**Modification Request for the University of Sydney Abercrombie Precinct
Redevelopment: Application Number: MP07_0158 MOD 3**

I am a resident of Darlington and I am writing to you to make the following objections in relation to the above development modification request by the University of Sydney because the modifications would have an unacceptable adverse impact on the amenity of nearby residents.

Ground Floor Plan
1:200@A1
11.10.13
4001_DA02-D

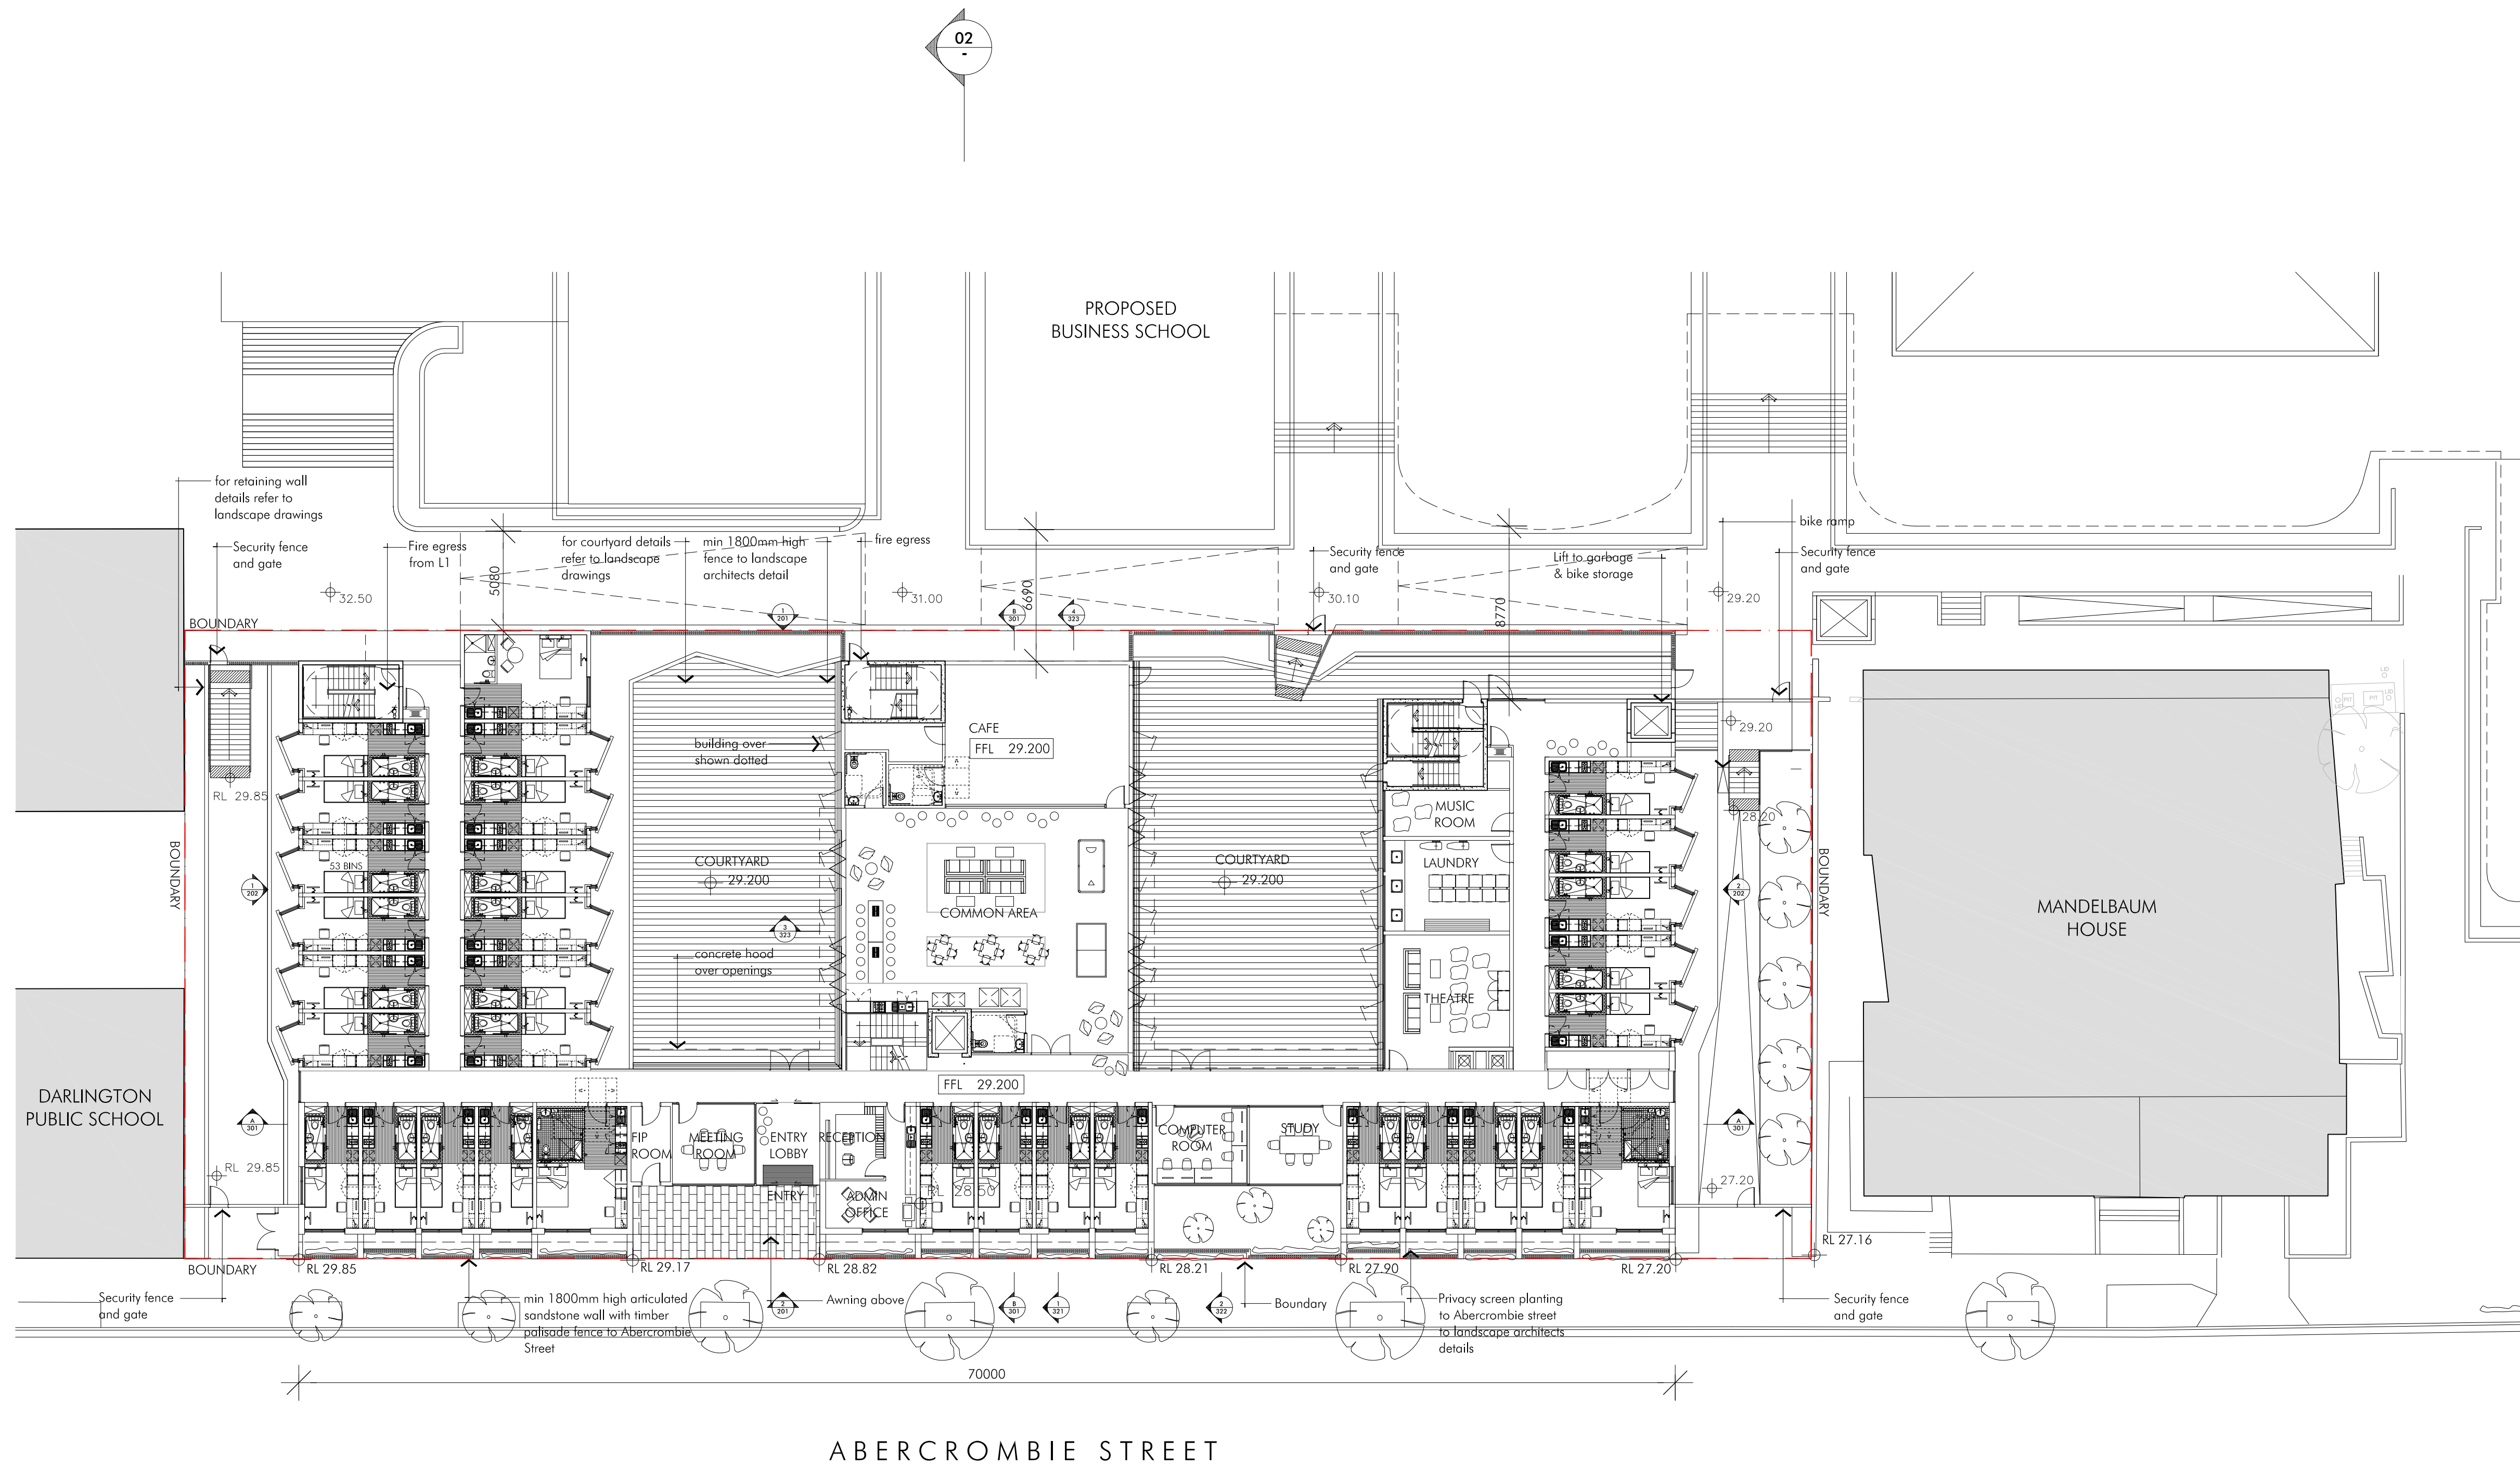
- The front of the Student Accommodation building should be built 2 metres back from the Abercrombie Street boundary. It should be set back from this boundary so that it is in line with Mandelbaum House as it was originally planned and presented to the community. The footprint of the buildings currently on the site, The Shepherd Centre and Boundary Lane Children's Centre, were built approximately 2 metres back from the Abercrombie Street boundary and align with Mandelbaum house. Therefore, the front footprint of the proposed Student Accommodation building should be the same as those buildings occupying the site at present and not be built up to the Abercrombie street boundary.

- The facade of the proposed Student Accommodation building does not reflect the heritage appearance of the Victorian terraces on Abercrombie Street as Mandelbaum House does. Therefore, it should be set back to allow for extensive vegetation and trees to be planted in front of the building on Abercrombie Street to help preserve the heritage streetscape and improve both the aesthetics and the environment of the street.
